M60/M62/M66 Simister Island Interchange

TR010064

7.21 APPLICANT'S RESPONSES TO EXAMINING AUTHORITY'S FIRST WRITTEN QUESTIONS

Version	Date	Status of Version
P01	5 November 2024	Deadline 3

Reproduced by permission of Ordnance Survey on behalf of HMSO. © Crown copyright and database right 2022. All rights reserved. Ordnance Survey Licence number 100030649.

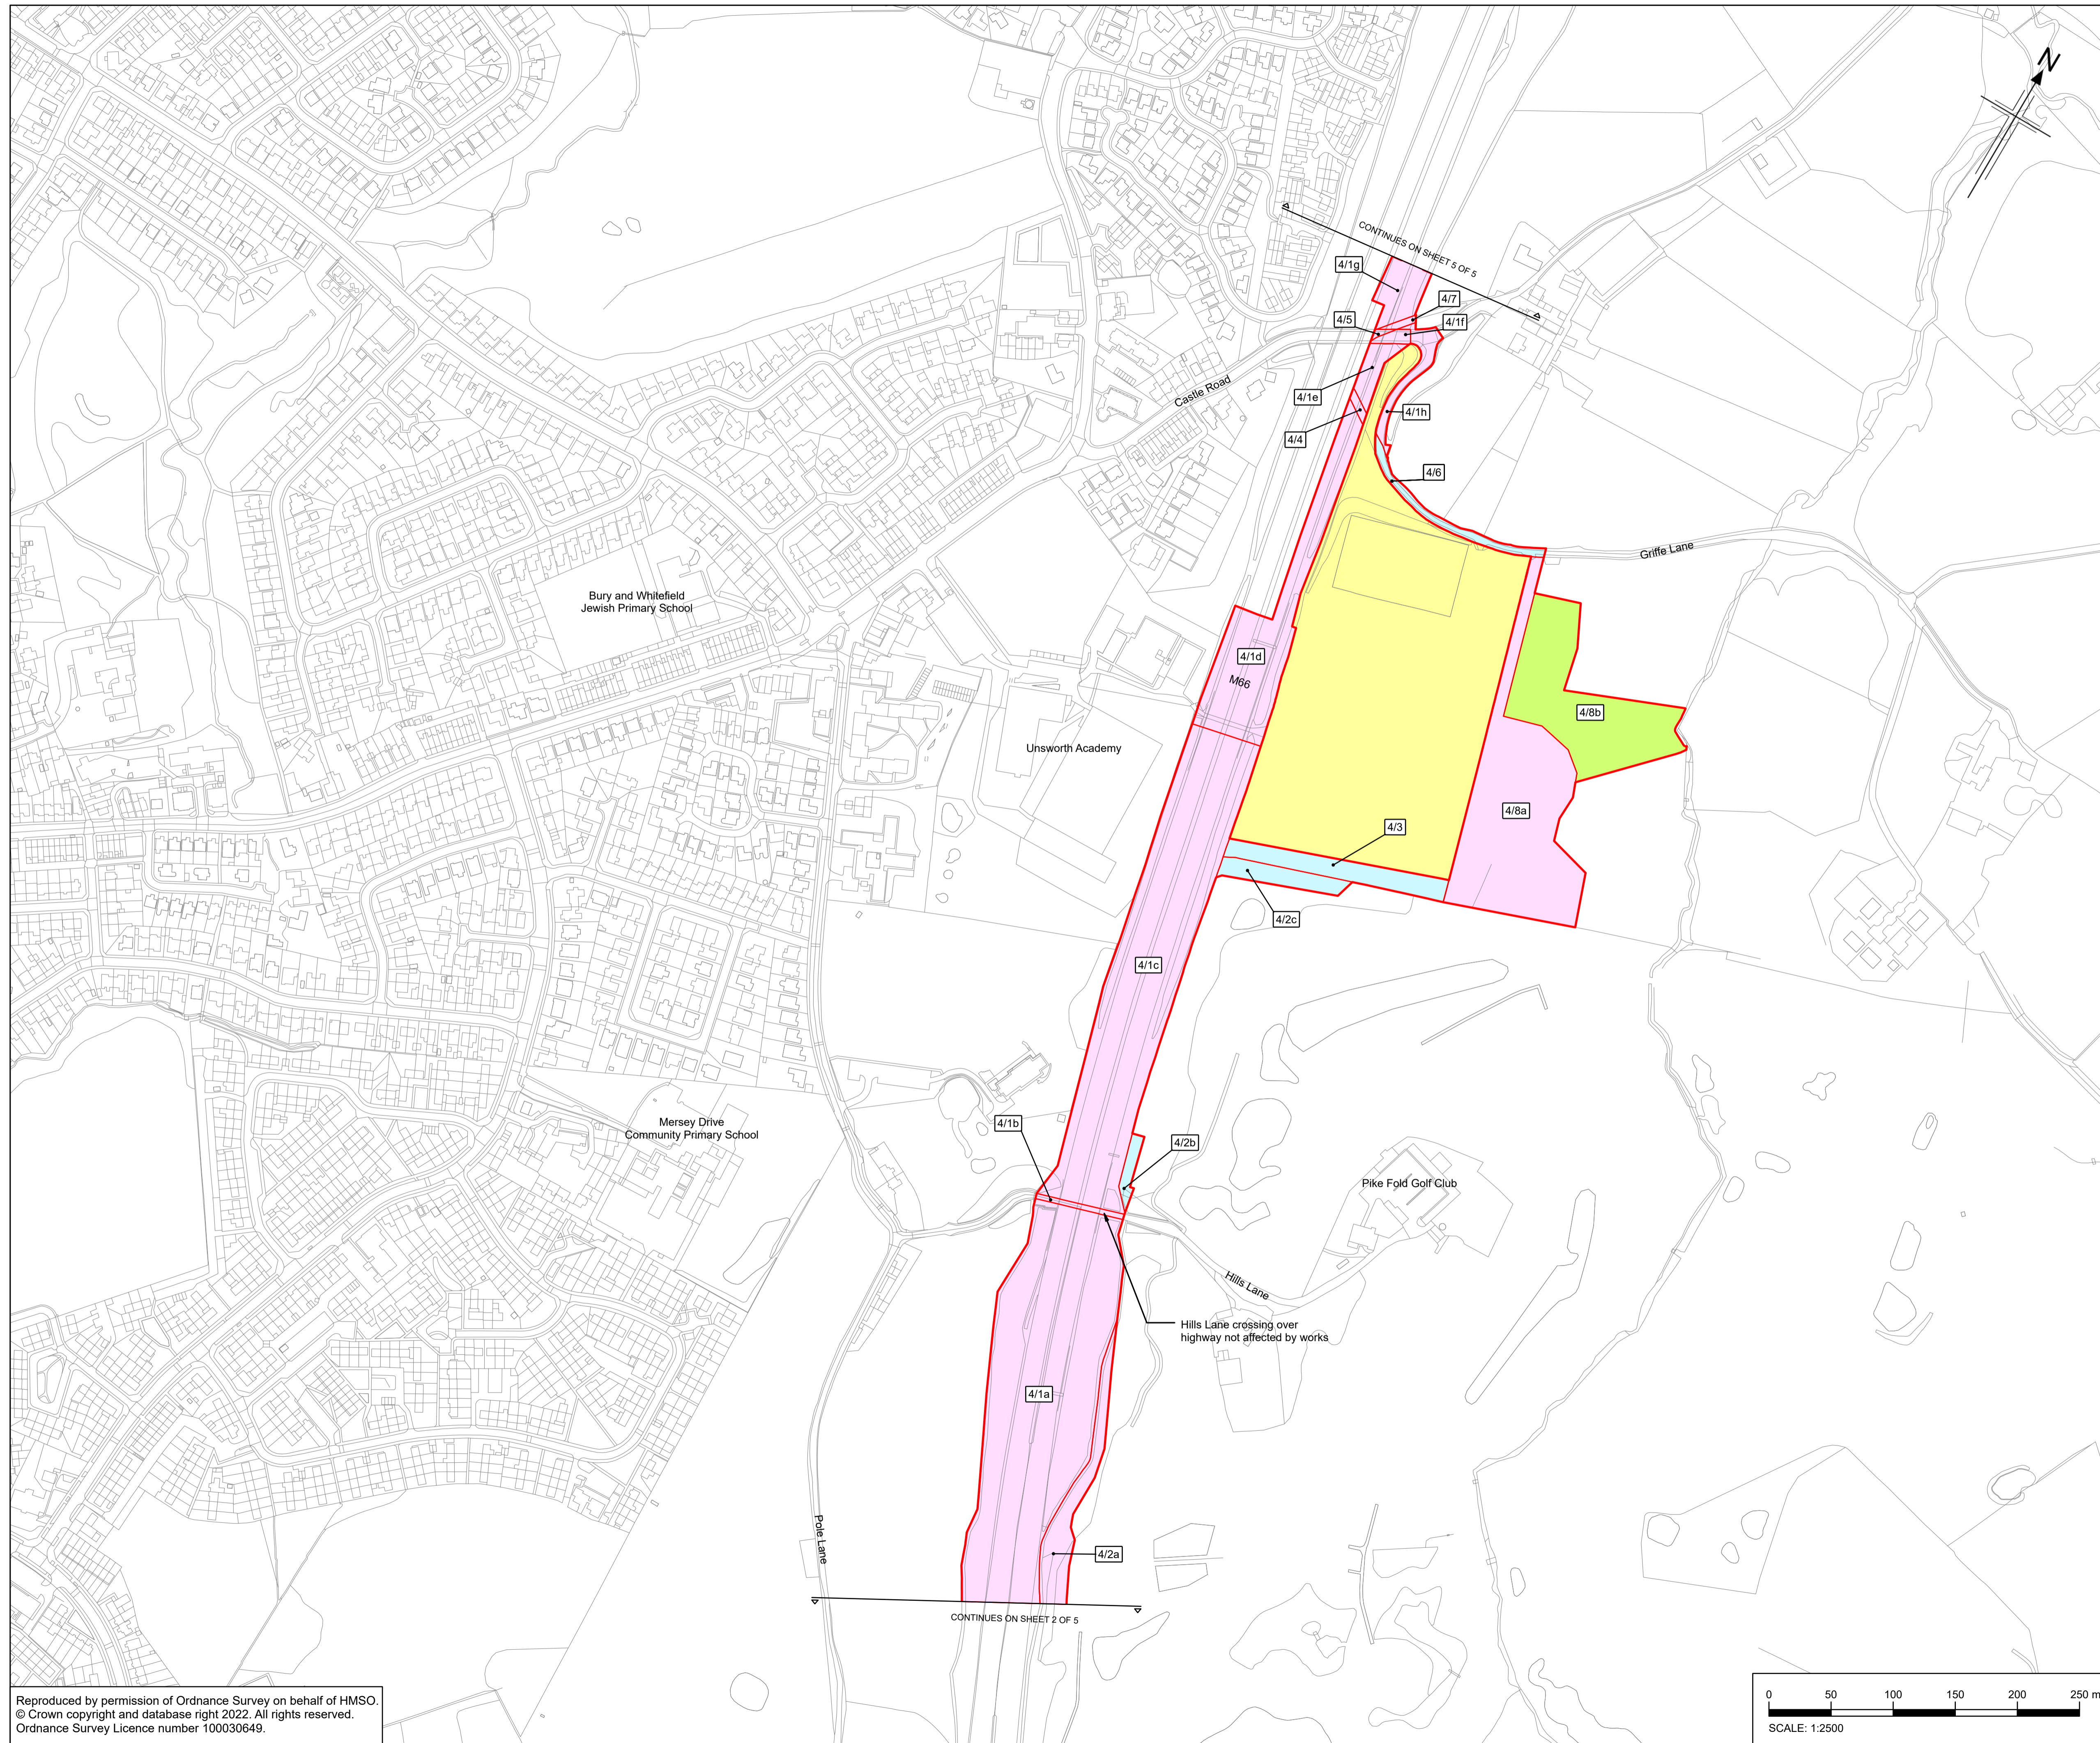
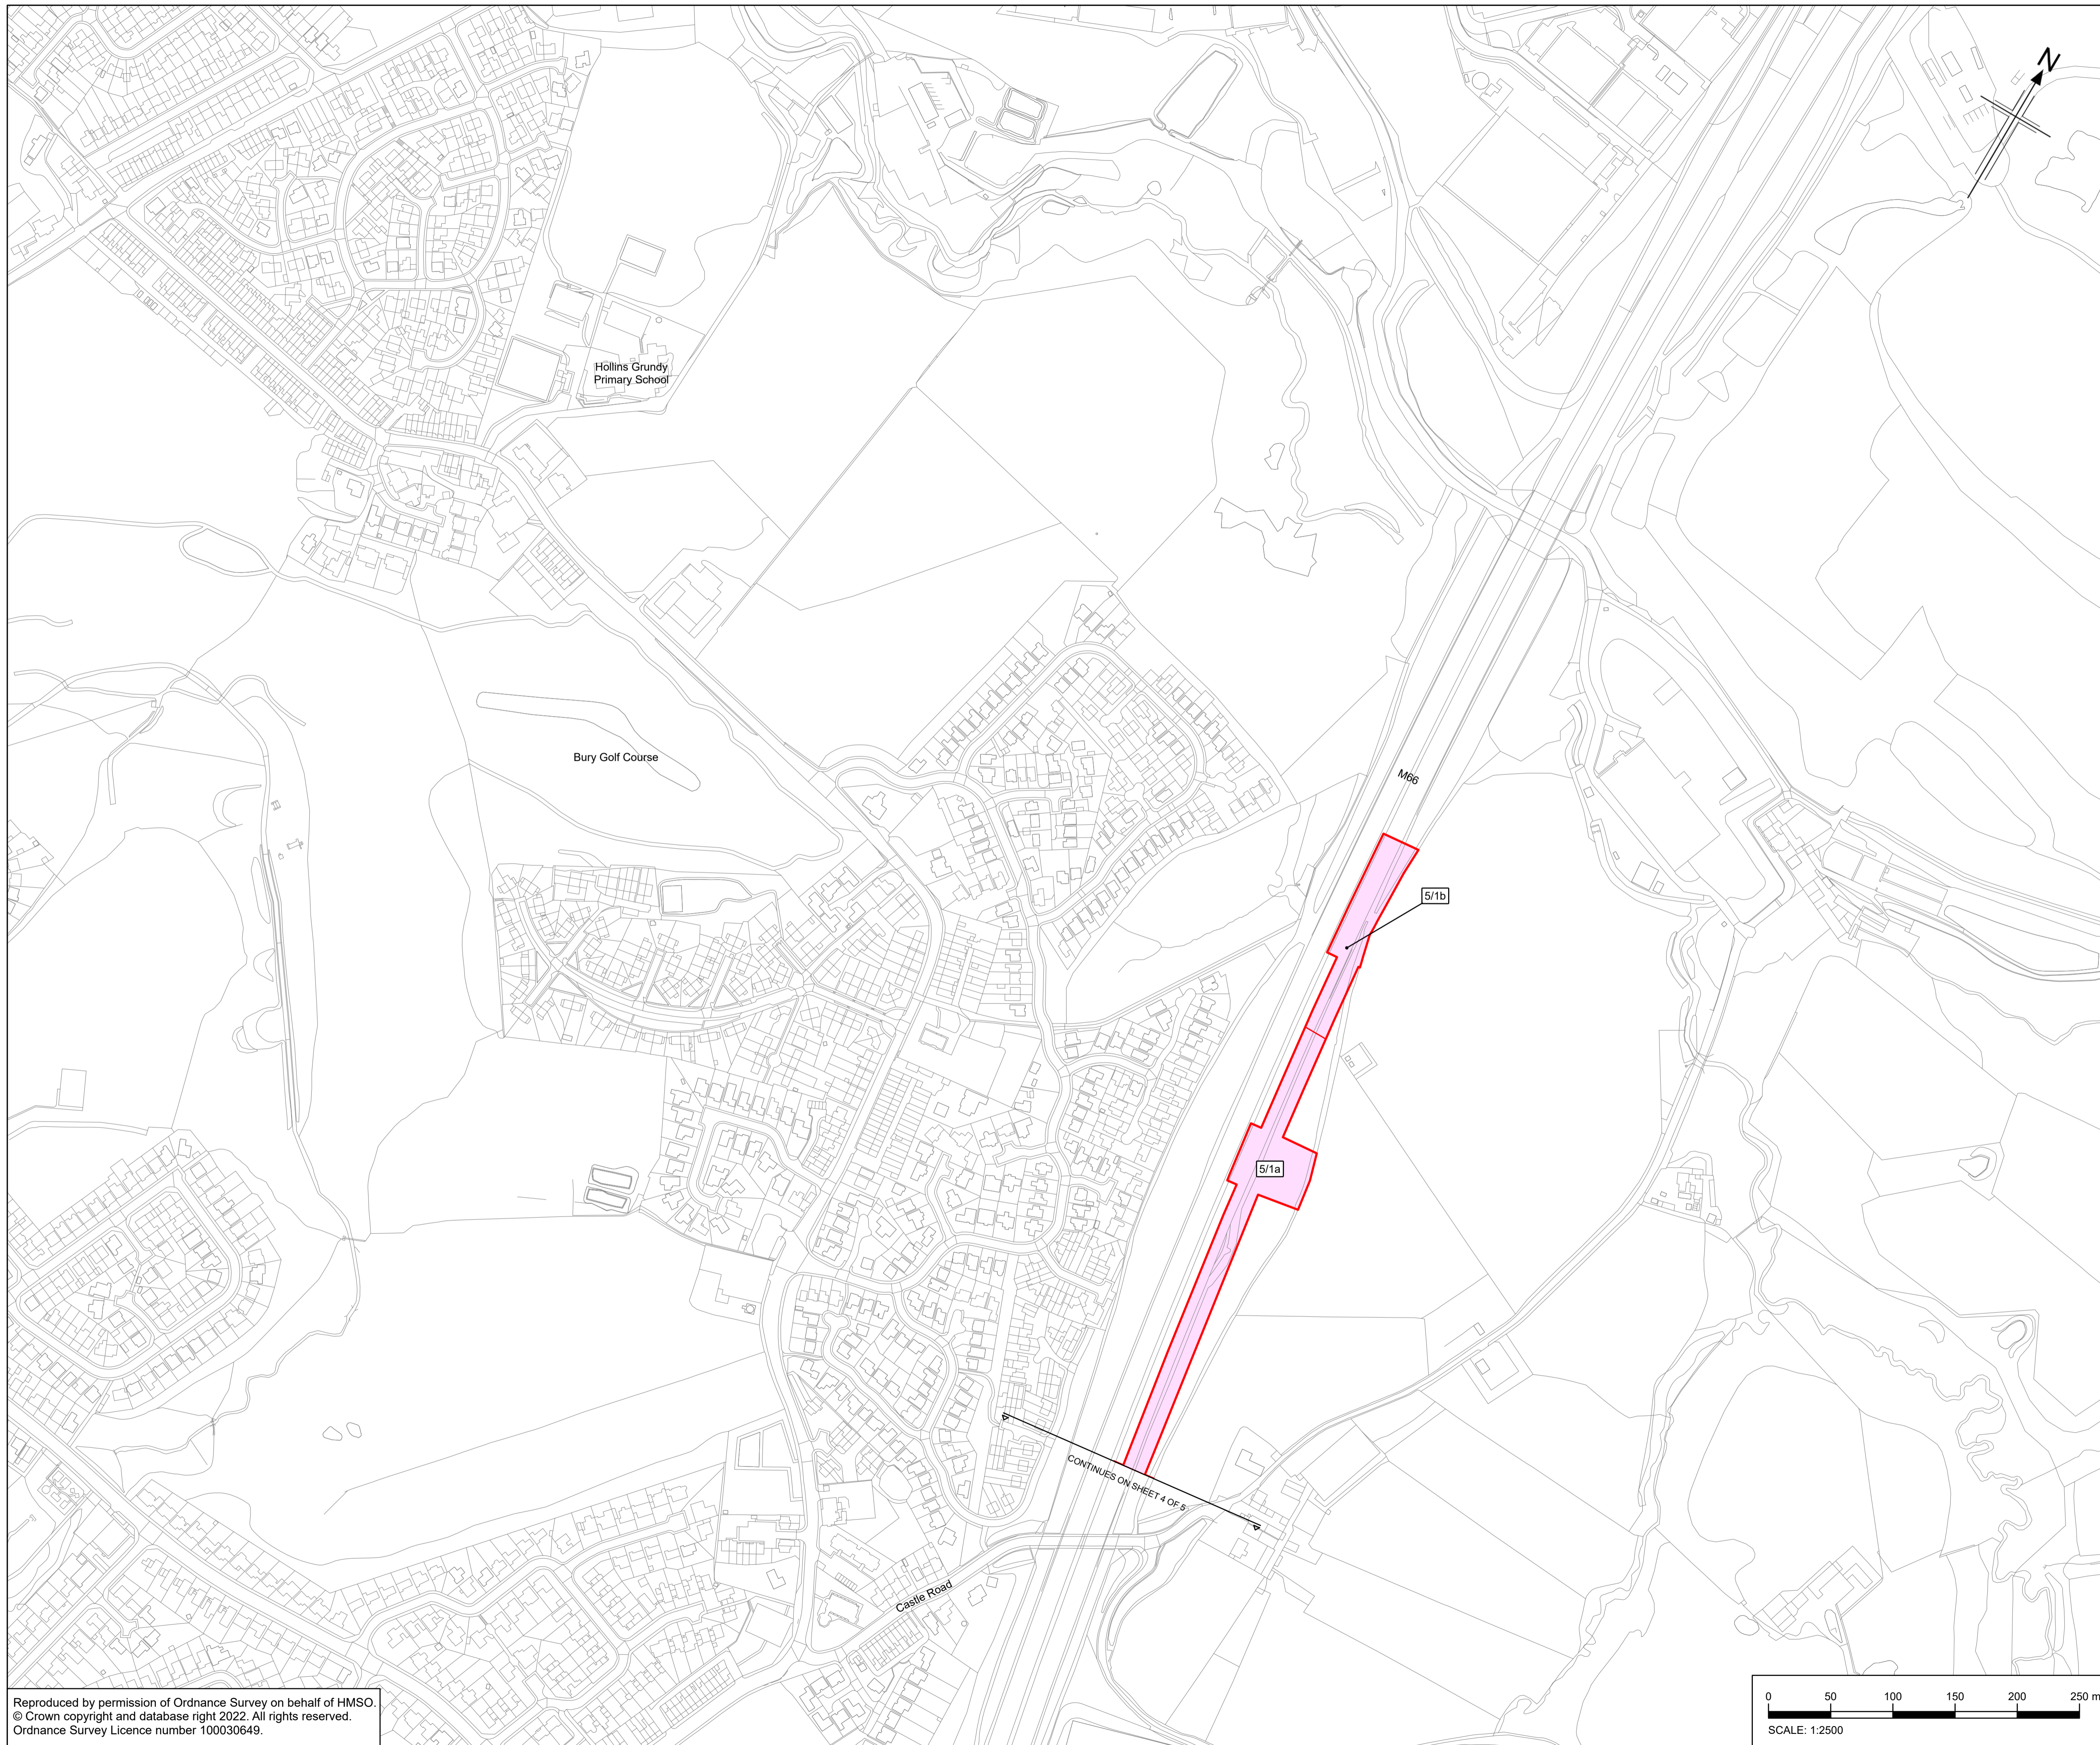
Written Question Number	Question to: -	Reference (in bold) & Question	Applicant's Response
		There is no plot 3/3 but there are two plots marked 3/4 on the Land Plans [AS-005]. Please correct.	
CA.1.5	Applicant	Clarification Clarify why you are requesting permanent land Rights over Egypt Lane (including the verges) (plots 2/1at, 2/4e, 2/4f, 2/1au, 2/4i, 2/4g, 2/4h, 2/1ax, 2/16e).	The Applicant confirms that permanent rights are required on Egypt Lane to facilitate off-network access for future maintenance of the permanent infrastructure provided as part of the Scheme, including but not limited to, the new drainage attenuation pond and swale, eastern abutment of Pike Fold viaduct, northern abutment of Pike Fold Bridge and the external earthworks and landscape planting on the new "northern loop".
CA.1.6	Applicant	Clarification Clarify why you are requesting permanent land Rights over Pole Lane and land adjacent to it (plots 2/4b, 2/13a and 2/13b).	The Applicant confirms that permanent rights at Plot 2/13a and 2/13b as shown on the Land Plans [AS-005] is required to maintain new trees, shrubs and hedgerow planting to be located on the eastern side of Pole Lane. Provision of these hedgerows has been agreed with the landowner and are shown on sheet 2 of 5 of Figure 2.3: Environmental Masterplan, of the Environmental Statement Figures [APP-057] and these new hedgerows are to be provided to facilitate visual screening. Rights are required over plot 2/4b to facilitate maintenance access to plots 2/13a and 2/13b.

CA.1.4	Applicant	<p>Land Plans</p>	<p>The Applicant has submitted revised Land Plans [AS-005] at Deadline 3 of the Examination to correct the error. Plot 3/3 is now correctly labelled in Inset 3B.</p>
